Householder Application for Planning Permission for works or extension to a dwelling.  
Town and Country Planning Act 1990

The proposal is to convert the existing garage into a kitchen area. This involves removing the existing (wooden) garage door and replacing with a brick wall. The bricks comply with building regulations which have already been granted. The bricks will be in keeping and match the bricks to the rest of the property (these will be reclaimed bricks)  
The size of the conversion does not change or alter the size or height of the current garage.  
I attach the original plans submitted in respect of the ERYC building Regulations service.  
I propose that the interior current wall that joins the current kitchen to the garage (as set out in the above plan) is removed to allow access from the current kitchen into the proposed area.  
I propose that the existent access to the side of the garage (side door) is half bricked up and a window is fitted, to fit with building regs as agreed.

In respect of Building Regs we have consulted with and had agreed said building regs by Richard Barnes BSc (Hons) MCIQB  
Building Control Surveyor  
BUILDING CONTROL PARTNERSHIP LTD

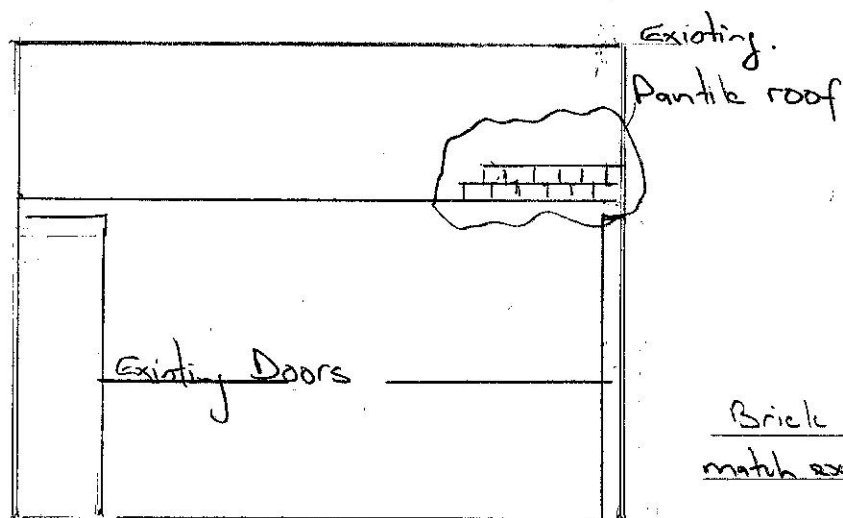
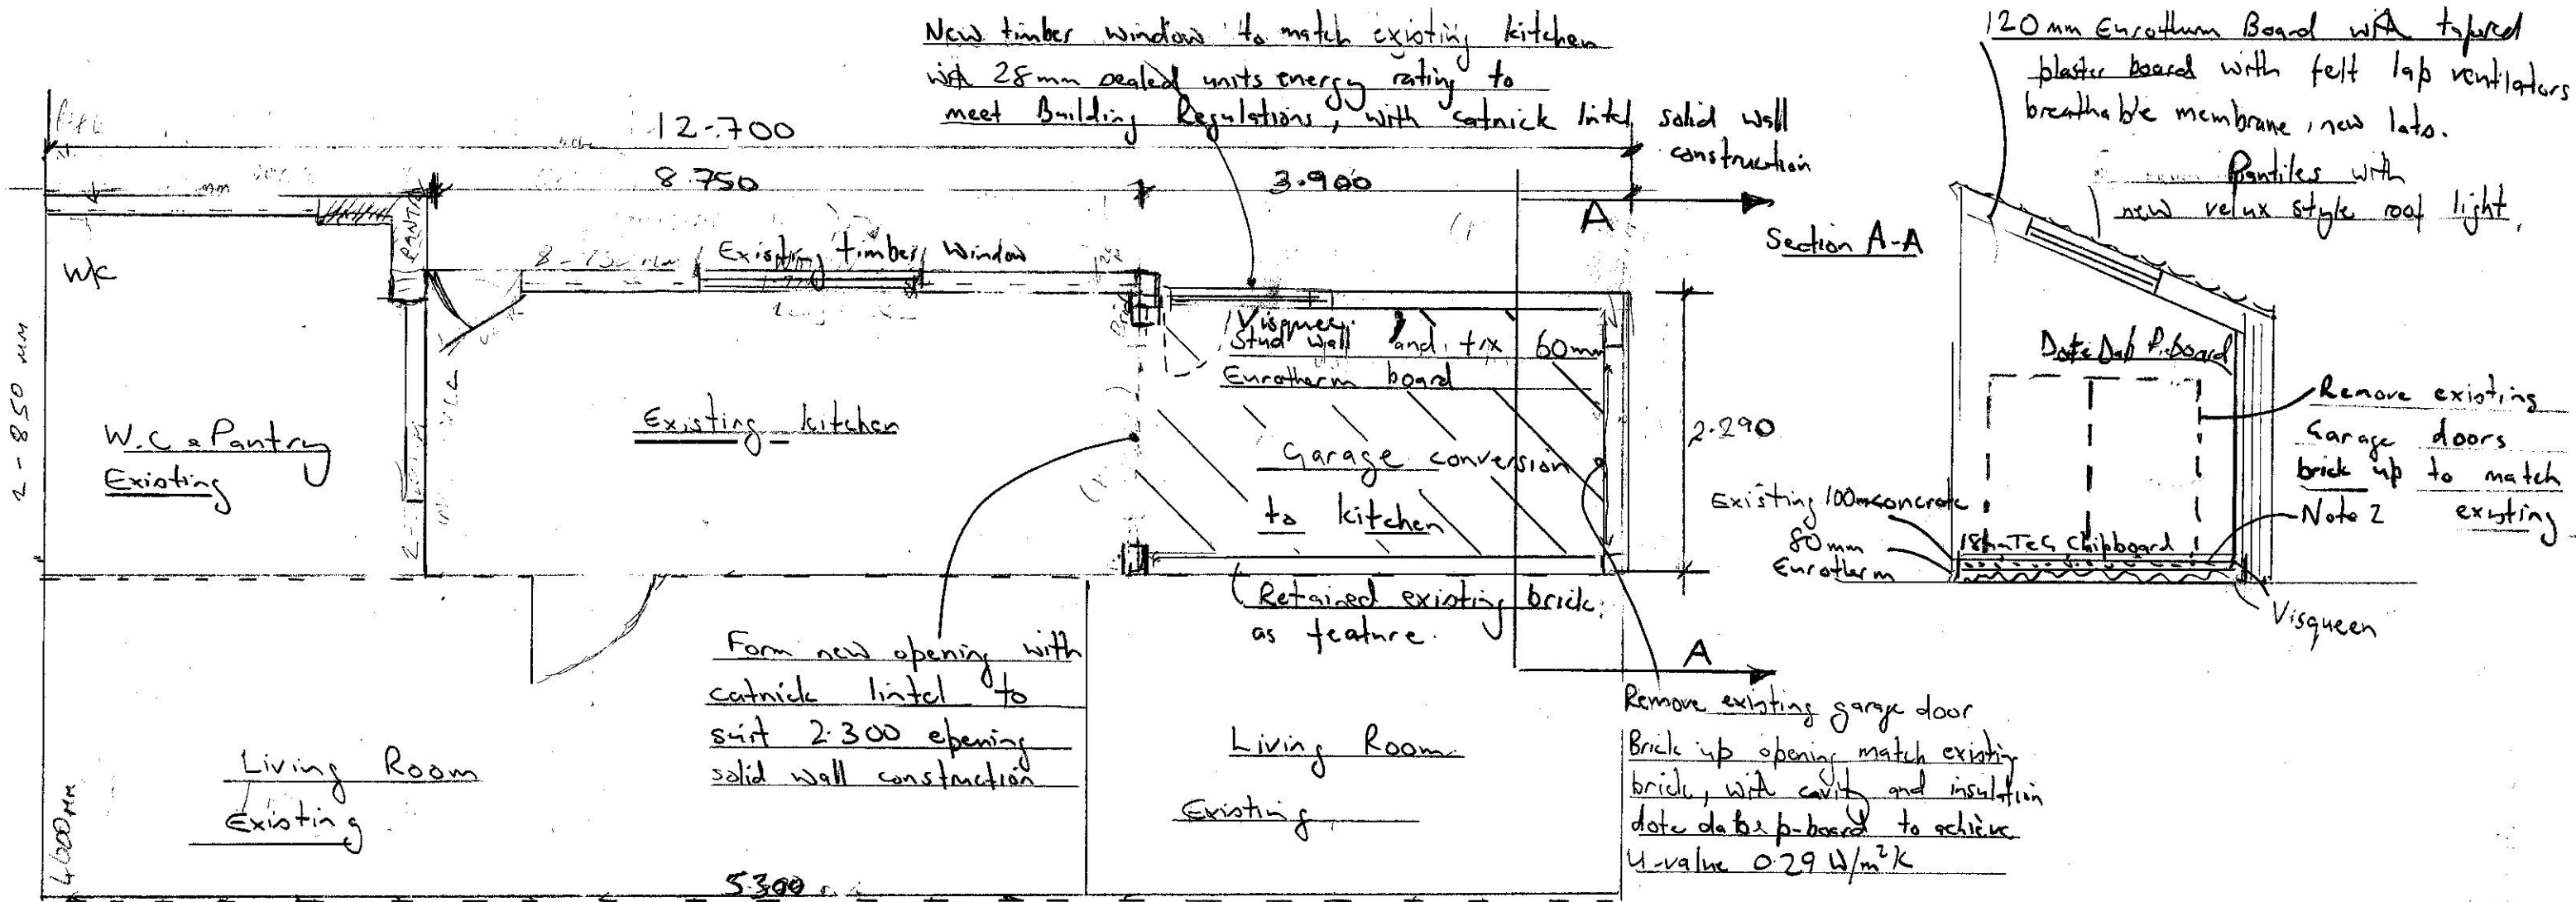
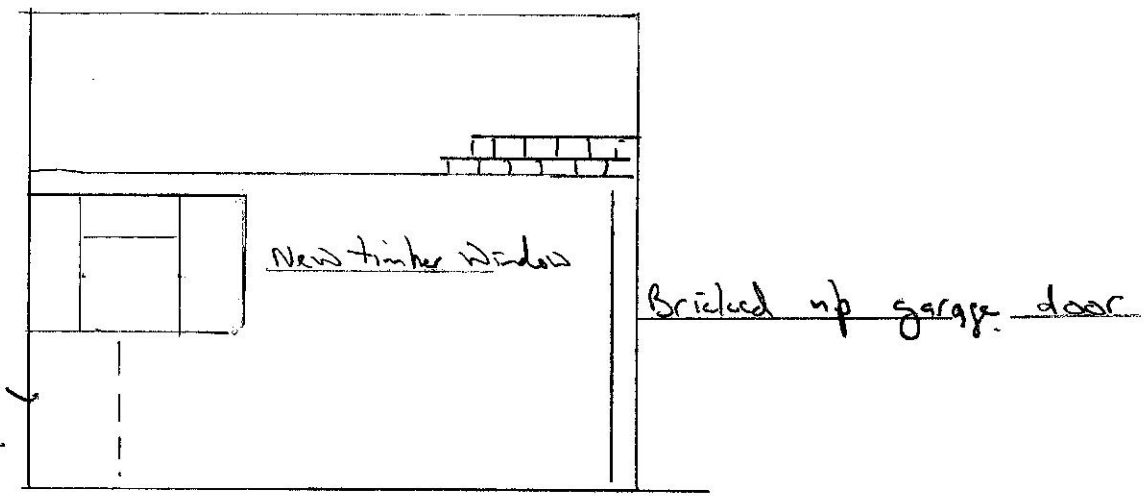
- 1 - The proposed brickwork to the garage door opening must be built on a suitable foundation and not the garage floor slab. This will enable a 225mm cavity drain below DPC to be provided or a cavity tray to be built in.

- 2 - The floor construction is dependent on height to match existing - this will require a DPM and 75mm PIR insulation (Kingspan, Celotex etc). You can either have a floating floor (22mm t&g chipboard over the insulation) or a screed (Min 65mm) if the levels will allow. U Value to be achieved is 0.22 W/m2K

- 3 - Existing external walls will need to achieve a U Value of 0.28 W/m2K. You may consider an rigid PIR wall insulation which is fixed to treated timber battens to the existing solid wall or insulate between and over a new internal timber stud.

- 4 - The existing rafters and purlins are over spanned for the proposed load. These will need to be replaced - according to TRADA tables a 147 x 45 C16 would be ok for the span at 400ctrs. This will not need support from a purlin and will allow enough room to insulated between and under the rafters. Please allow for double rafters either side of the Velux windows.

- 6 - The kitchen will required a mechanical extract fan ducted to the outside which an extraction rate of 30l/s.
- 7 - The electrical installation must be carried out by a Part P registered electrician who can issue a installation certificate and notification to a competent person scheme such as NICEIC, NAPIT, ELECSA or STROMA.
